**FINAL DRAINAGE REPORT
FOR
STIMPLE SUBDIVISION
FILING NO. 1**

Job No. 1185.80

PCD Project No. MS-244

STIMPLE SUBDIVISION FILING NO. 1
FINAL DRAINAGE REPORT
DEVELOPED DRAINAGE MAP

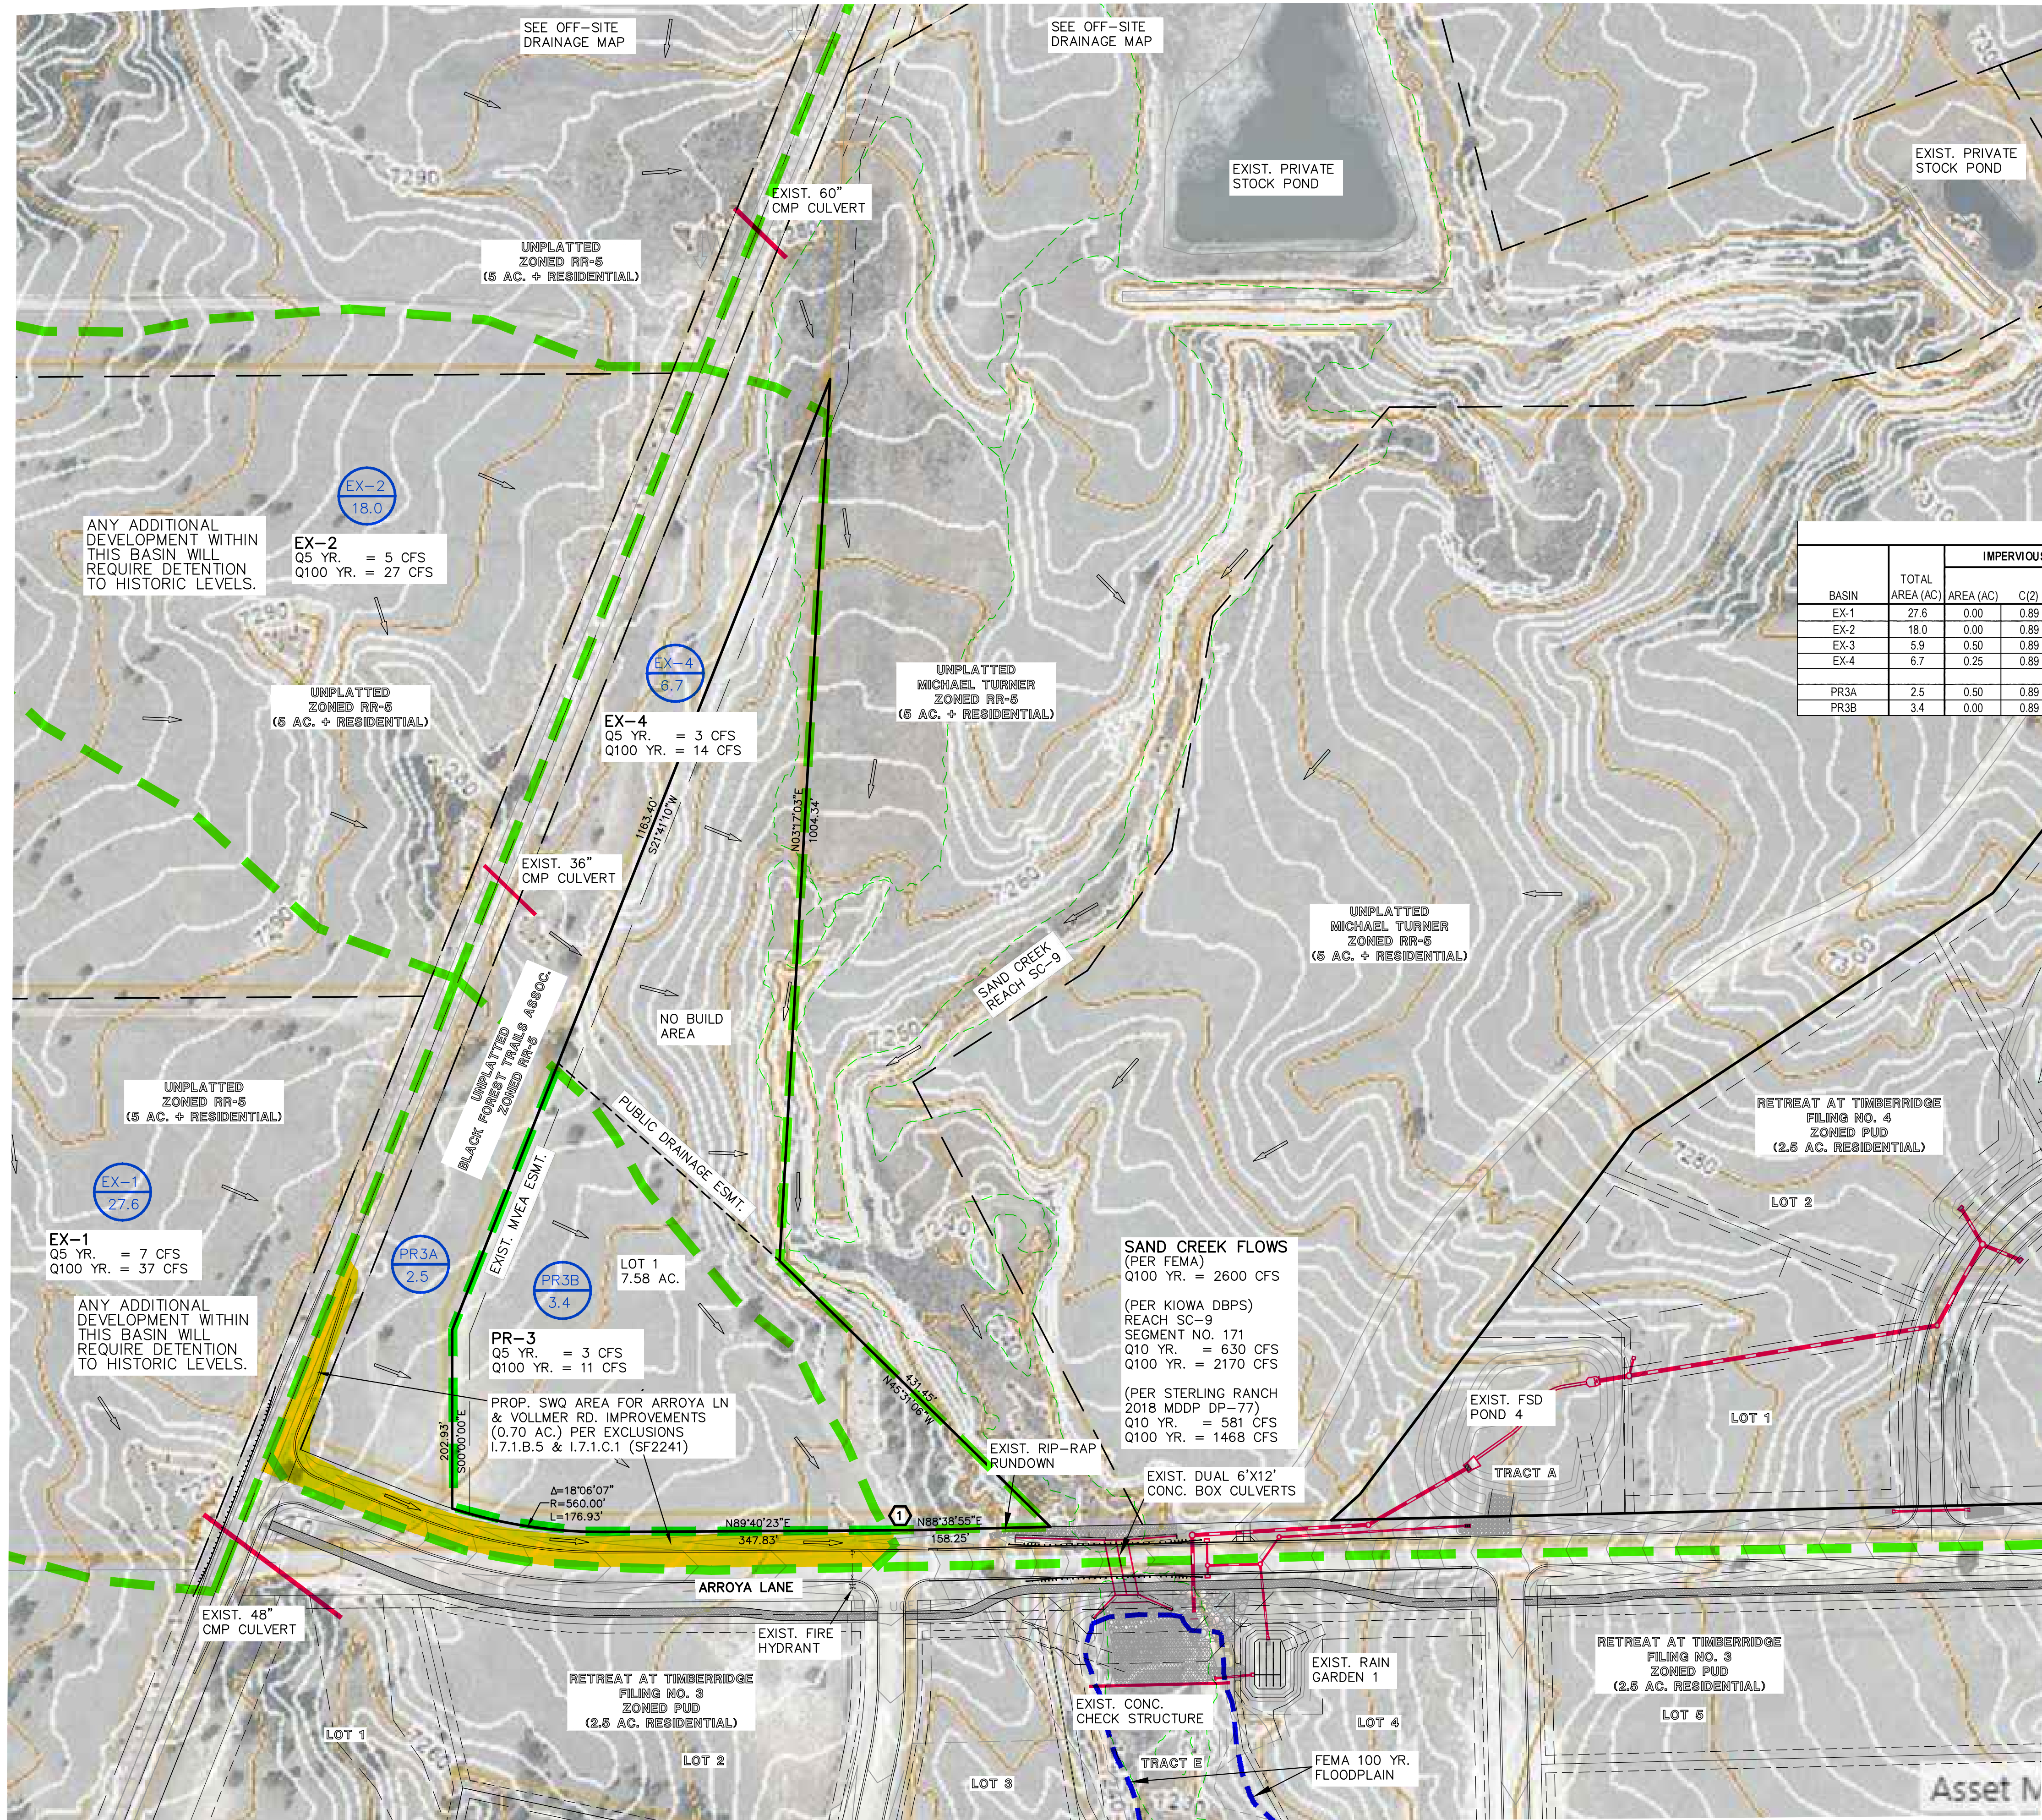
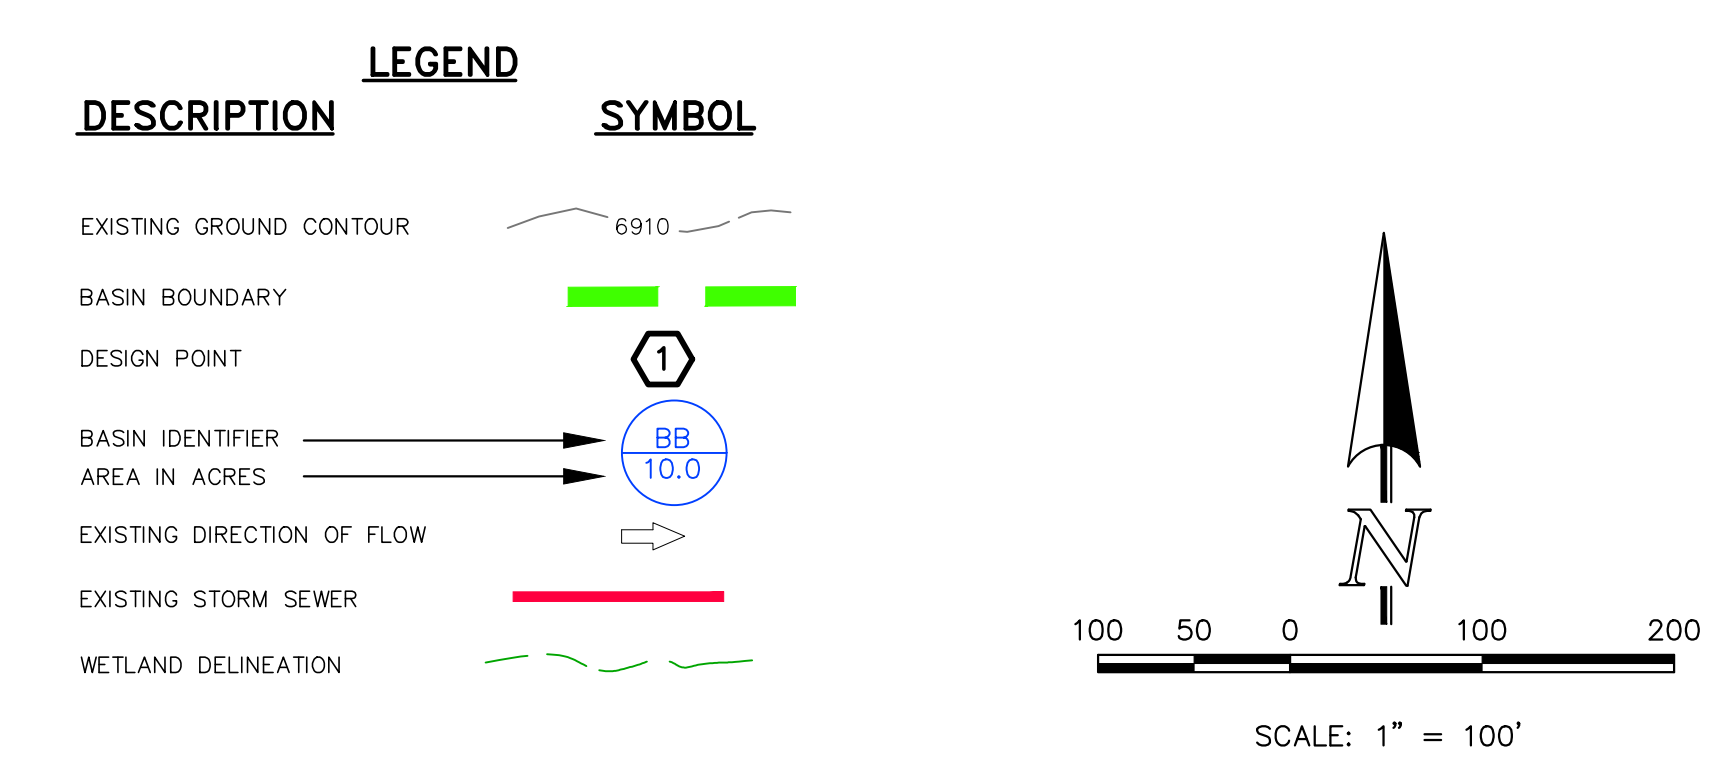
Unresolved:
Include statement about TR 3 stating future rain garden would be provided but based upon what is being proposed now, it is no longer needed.
